Ribble Valley Borough Council
Housing & Development Control

Application no: **3/2023/0096**

Address: **26 Oakdale Drive Whalley BB7 9FW**

Proposal: **Proposed conversion of the detached garage to living accomodation.**

**EXISTING SITE PLAN**  
Scale 1:200

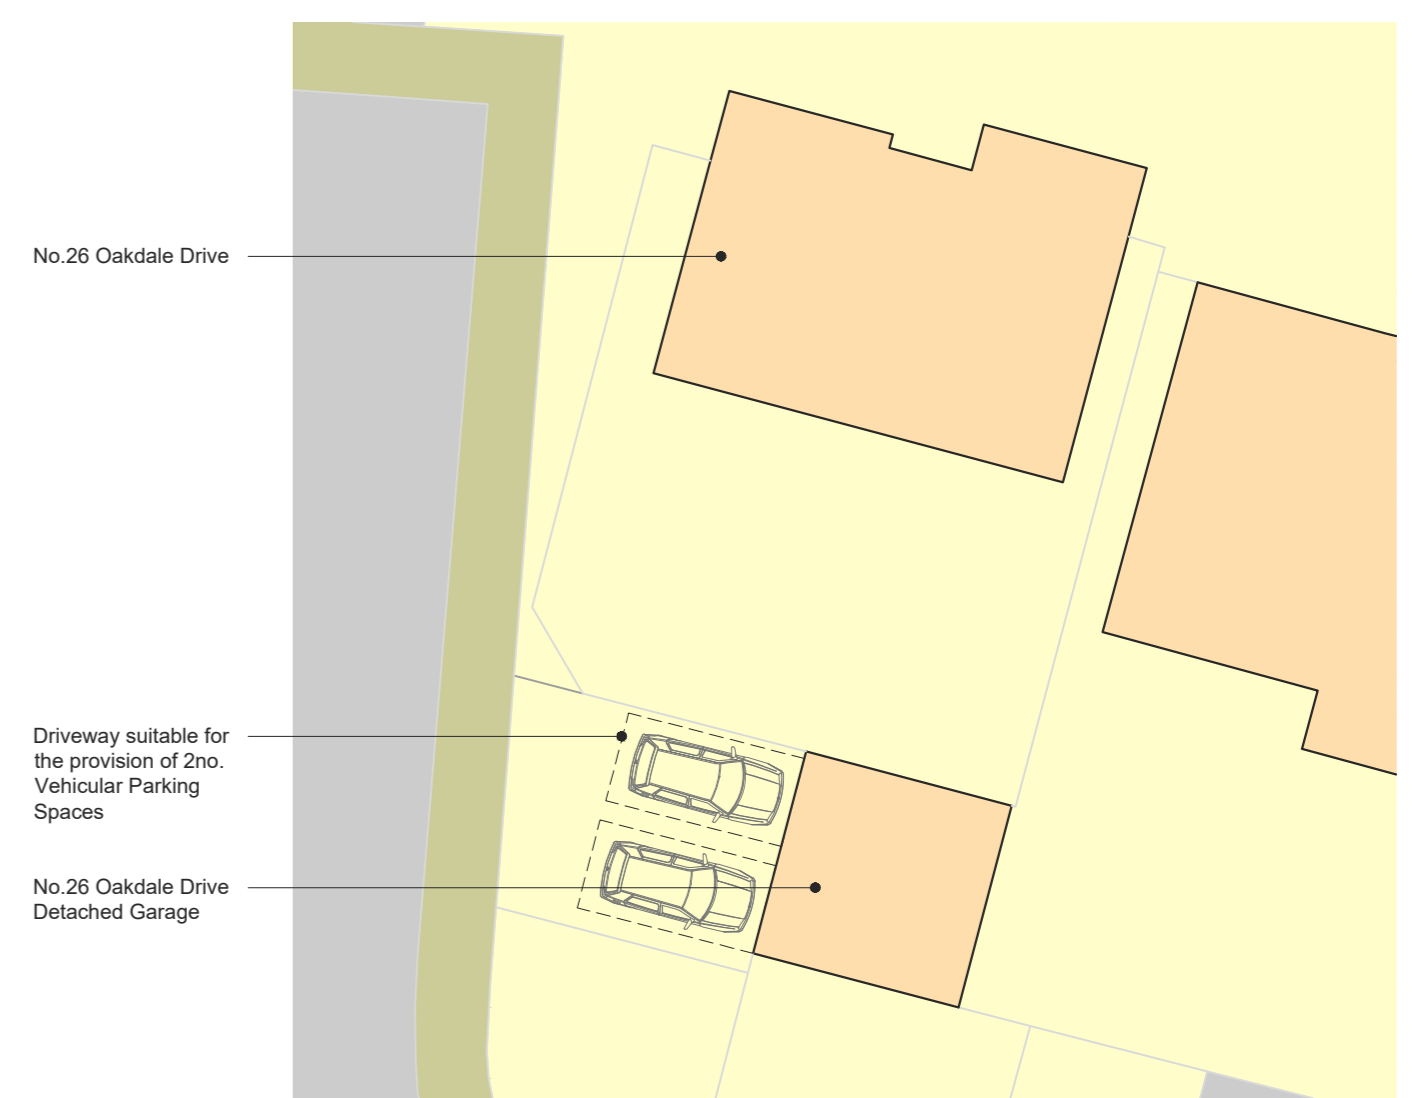
The LHA have reviewed RVA drawing number 2275-P01 titled "Existing Site Plan" and are aware that the site will continue to provide 2 car parking space for the 4-bed dwelling, following application reference 3/2023/0091.

The LHA are aware that the internal dimensions of the garage measure 5.3m x 5.3m, which does not comply with the LHAs guidance when providing a car parking space due to the LHA requiring the minimum internal dimensions to be 6m x 3m.

Therefore, the conversion of the garage will not impact upon the parking arrangements at the site and so the LHA have no objection to the proposal.
